**Hunter Regional  
Development Committee**

**PROPOSED RECYCLING FACILITY- THE WEIR ROAD, TERALBA (MP 08\_0079)**

The Committee considered a Traffic Impact Assessment prepared by AECOM dated 22 June 2010 for the proposed Recycling Facility 80 The Weir Road, Teralba.

Figure 4.1: Concept Design of Proposed Access at The Weir Road

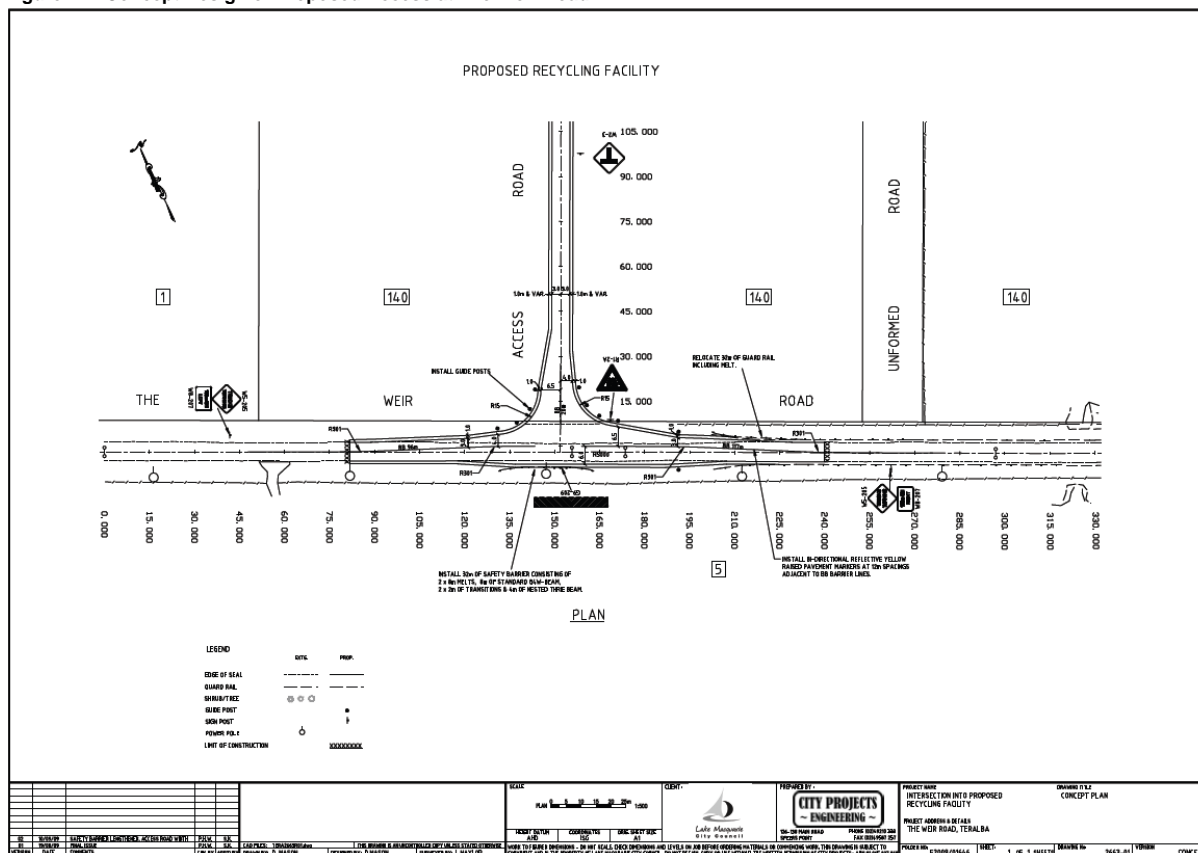
1. Given the number of trucks expected to enter and exit the proposed development, a Type AUR intersection / access should be constructed at the site access in lieu of the Type BAR.
2. Provision should be made for on-road cyclists at the intersection / access.
3. The line marking / sign posting plan for the intersection / access should make provision for truck turning signs.
4. Street lighting should be provided at the intersection / access in accordance with Australian Standard AS 1158.
5. The weigh bridge should be relocated further into the site to ensure vehicles do not queue back onto The Weir Road.
6. All roads and parking areas within the site should be sealed.
7. A truck management plan should be prepared. This should include a restriction on vehicles travelling to and from the site immediately before and after school hours.
